8 February 2021

**Re: Independent Flooding Assessment  
SSD 10416: Powerhouse Parramatta  
Review of Flooding Aspects**

# SUMMARY OF FLOOD ISSUES – PROPOSED PARRAMATTA MUSEUM

Figure 1 – Plan and Section of Retaining Wall Adjacent to 330 Church Street

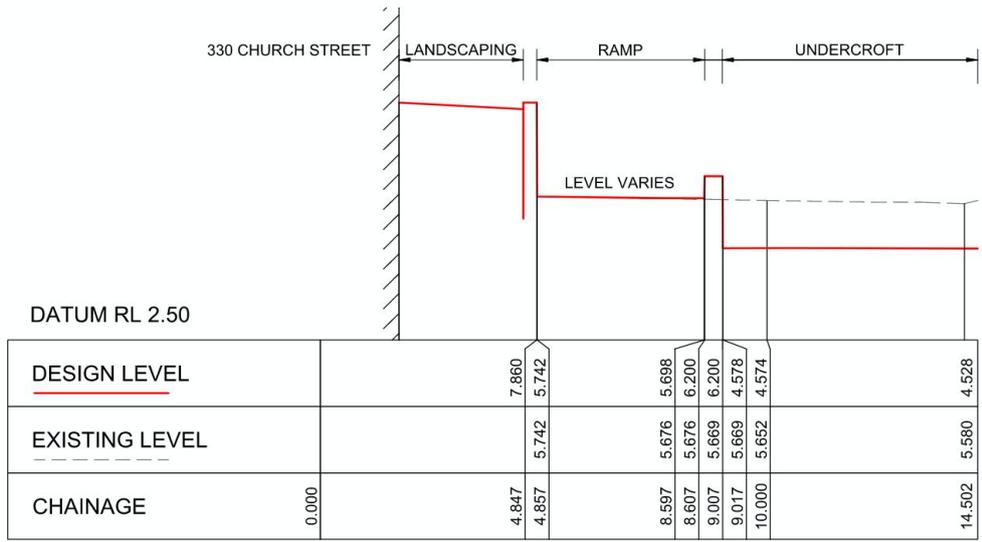
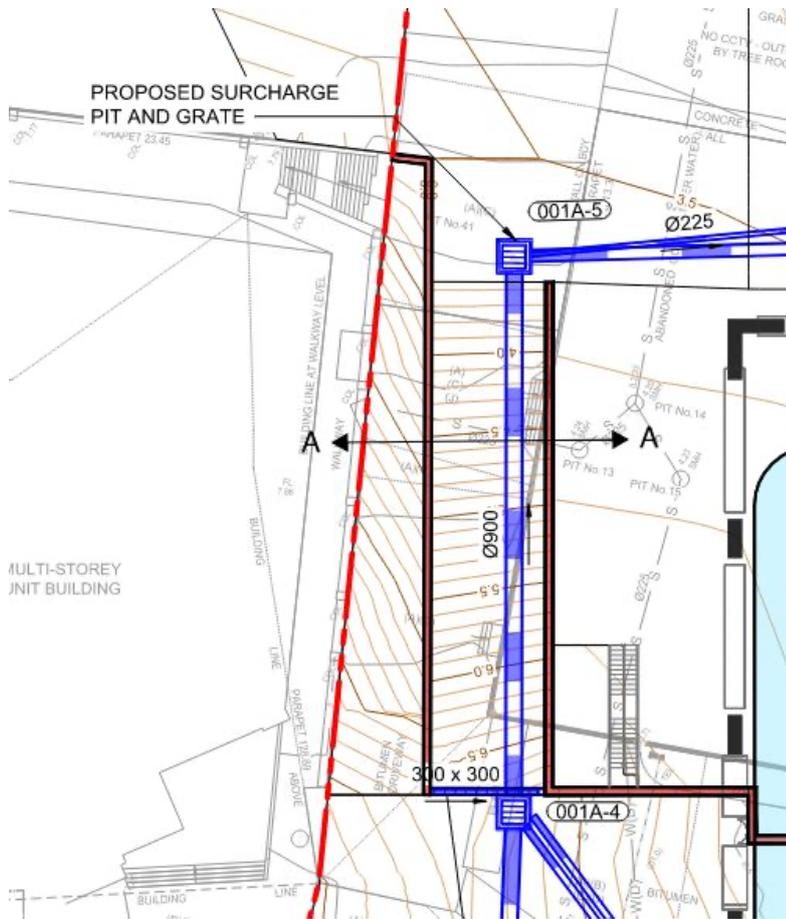
The peak flood level impacts on surrounding properties are within acceptable limits with the exception of 330 Church Street where a retaining wall is recommended as a Condition of Consent (refer Section 6.2).

7. Further details have been provided on protection for 330 Church Street. This is to include a retaining wall to support the ramp connecting the southern end of Dirrabarri Lane to the

Parramatta River foreshore. The top of the retaining wall supporting the west end of the ramp, wraps around to the corner of 330 Church Street. The top of the wall is to be at the 1% AEP flood level plus 0.5m freeboard.
